The Secretary
NSW Planning & Environment
-

I refer to the Department's letter of 14 January 2019 regarding State Significant Development SSD 8800 at 1 Eels Place, Parramatta [Lot 369 DP 752058, Lot 7054 DP 1074335 & Residual Crown Plan 80-3000 (Sydney)] for 'Parramatta Leagues Club Hotel. Construction of a 17 storey hotel comprising 209 hotel rooms, one basement level for services, ancillary uses including a pool, gym, cafe, bars and function room, vehicular access from O'Connell Street, public domain works and tree removal'. Submissions need to be made to the Department by 22 February 2019.

DRAWING TITLE
GA FLOOR PLAN - LEVEL B01 (BASEMENT) - PLANT & HOTEL BOH

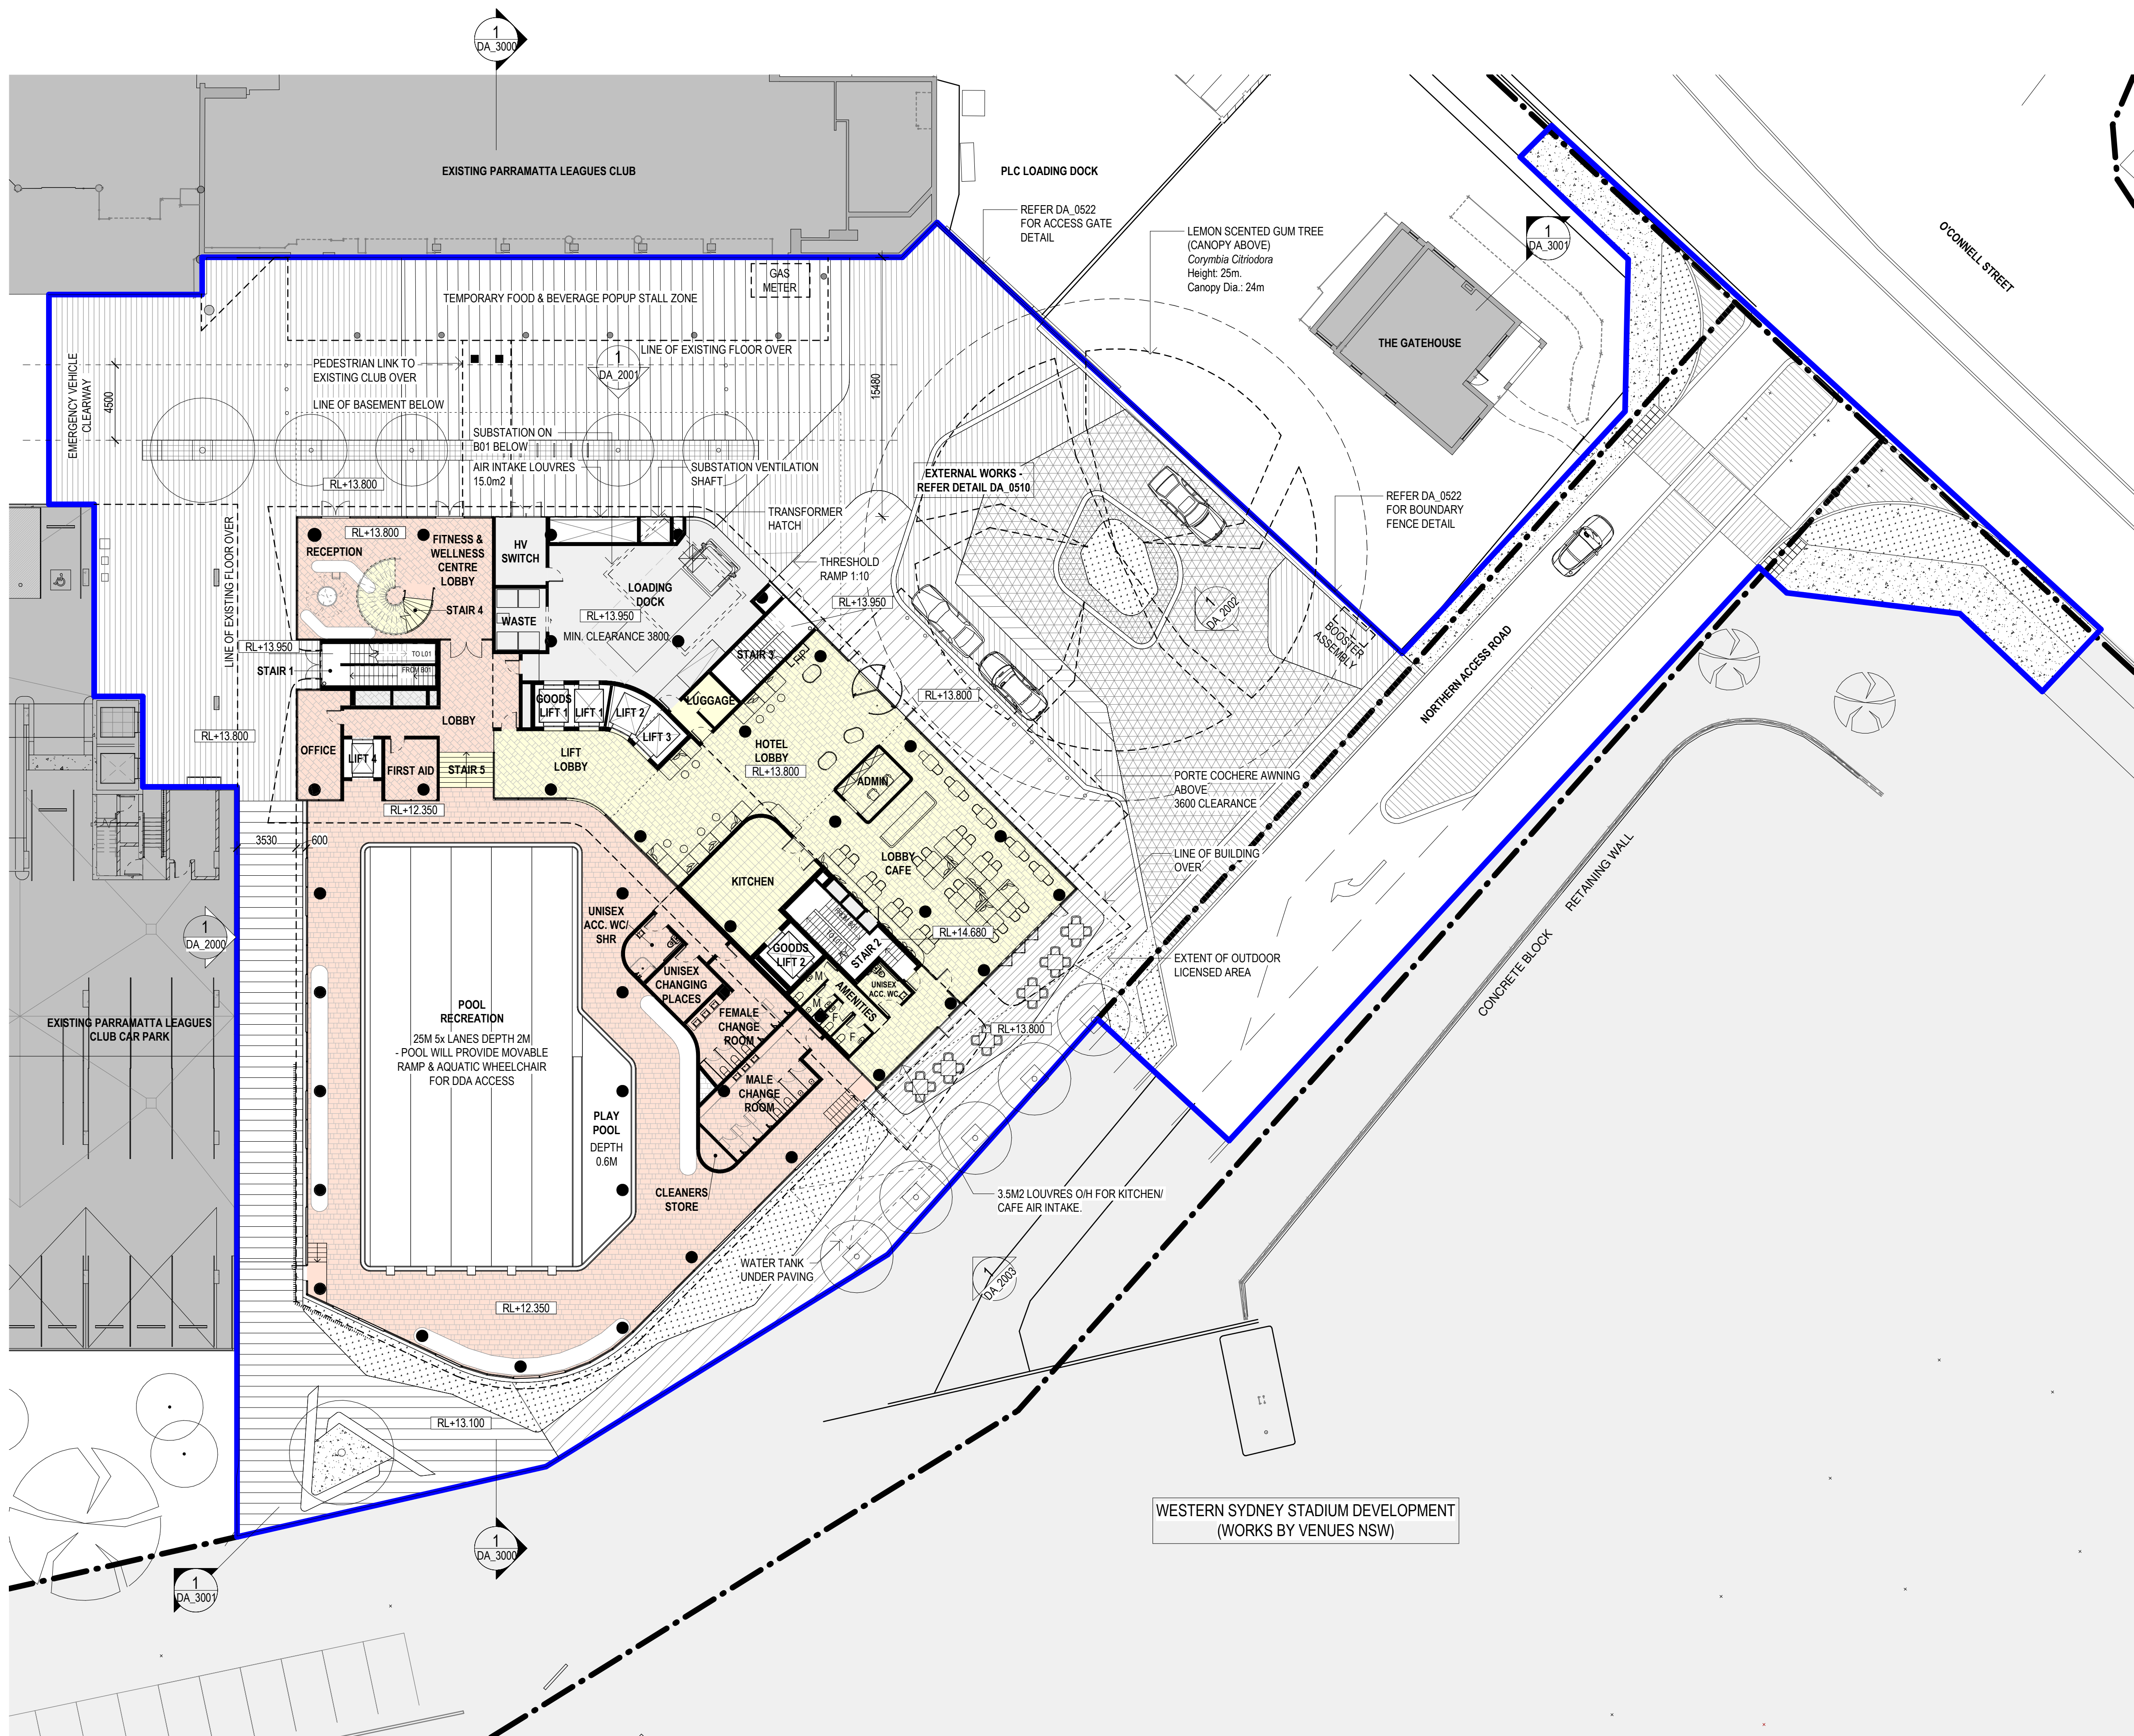
In regards to the new substation Endeavour Energy has noted that as shown in the following extract of Architectural Plans Attachment A2 it is proposed to be located within the Basement.

In this instance the proposed indoor substation being in the basement is not compliant with Endeavour Energy's standards and presents potential access, safety and reliability risks. As an alternative, different locations for the new substation or the augmentation of the existing nearby substations may be an option. Where all other options have been exhausted, if the substation does not comply with Endeavour Energy's standards, the applicant must request a dispensation in accordance with Endeavour Energy's Company Procedure GAM 0114 'Granting Dispensations for Engineering Documents' which states:

The fact that provision is being made for the substation is a positive. Endeavour Energy's general requirements is for a substation be at ground level and have direct access from a public street. Generally it is the Level 3 Accredited Service Provider's (ASP) responsibility (engaged by the developer) to make sure that the substation location and design complies with Endeavour Energy's standards the suitability of access, safety clearances, fire ratings, flooding etc. As a condition of the Development Application consent Council should request the submission of documentary evidence from Endeavour Energy confirming that satisfactory arrangements have been made for the connection of electricity and the design requirements for the substation, prior to the release of the Construction Certificate / commencement of works.
